**Recommendation:** Approve

**Applicant:** Rectory Homes Ltd

**Proposal:** Discharge of Conditions 5 (surface water drainage details), 8 (full specification details of parking and manoeuvring areas) and 9 (full specification details of accesses, driveways and turning areas) of 19/02948/F

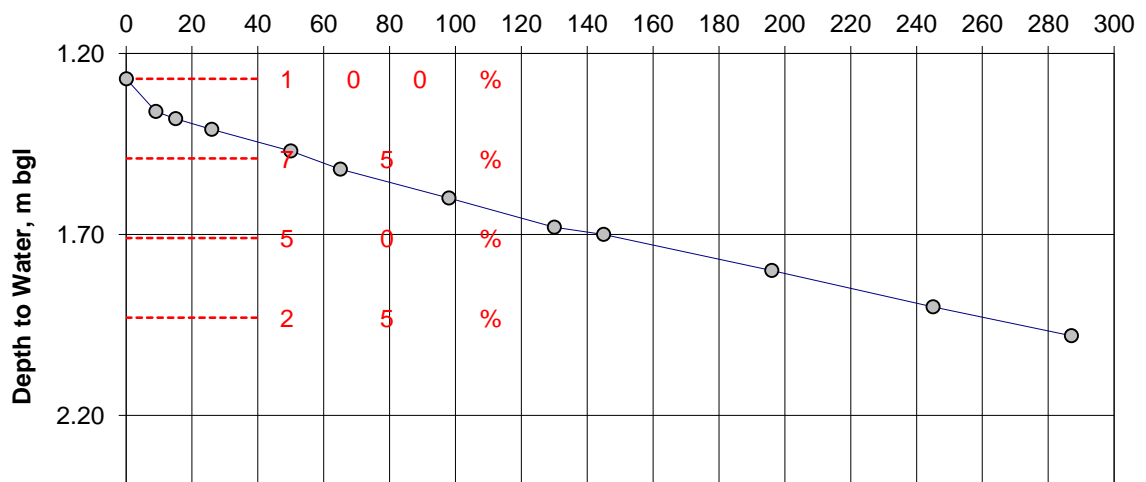
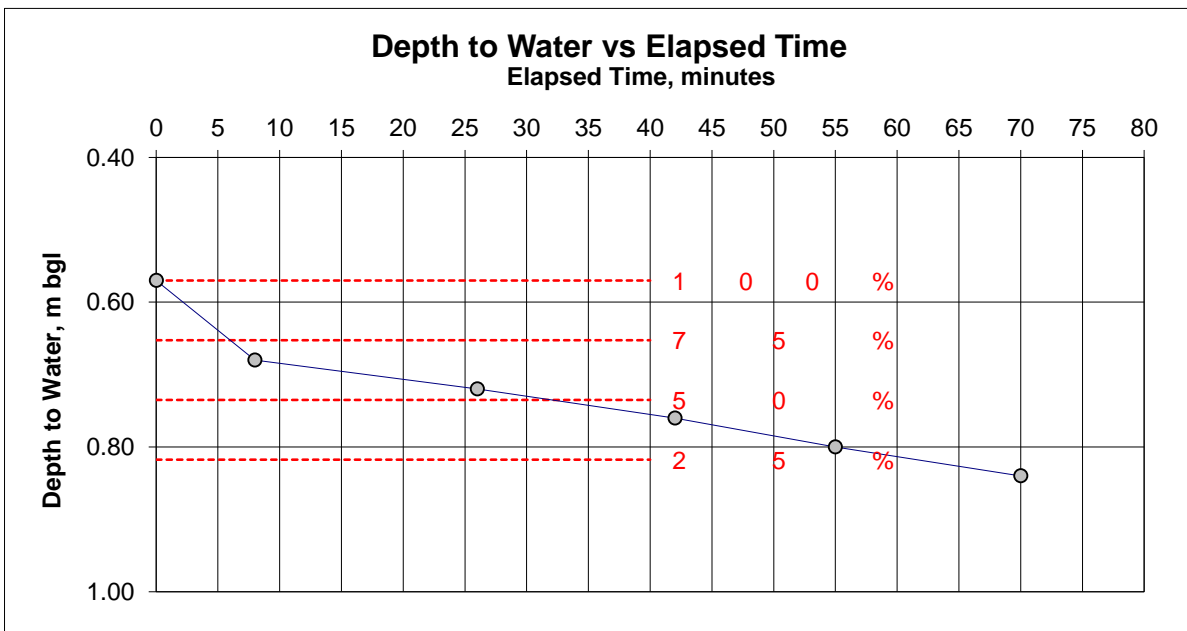
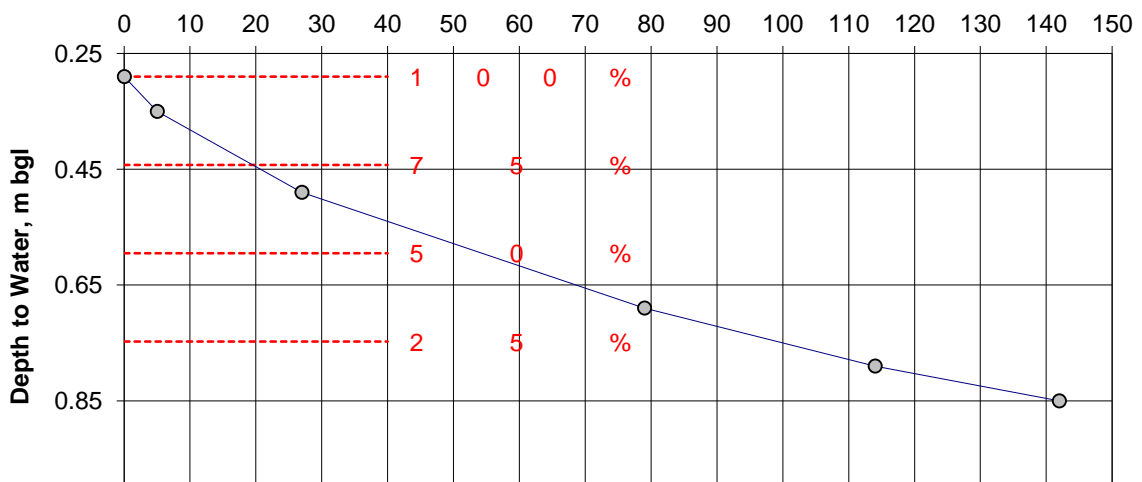
Infiltration testing carried out needs more results to conclude with an accurate rate. Currently, the submitted data only has 1 test for SA1 and 2 tests for SA2. As these two are the preferred location of soakaways, we will need to see at least 2 tests at these locations.

### 5.4. OCC LEAD LOCAL FLOOD AUTHORITY: Response on additional information 28-06-22 – No objection
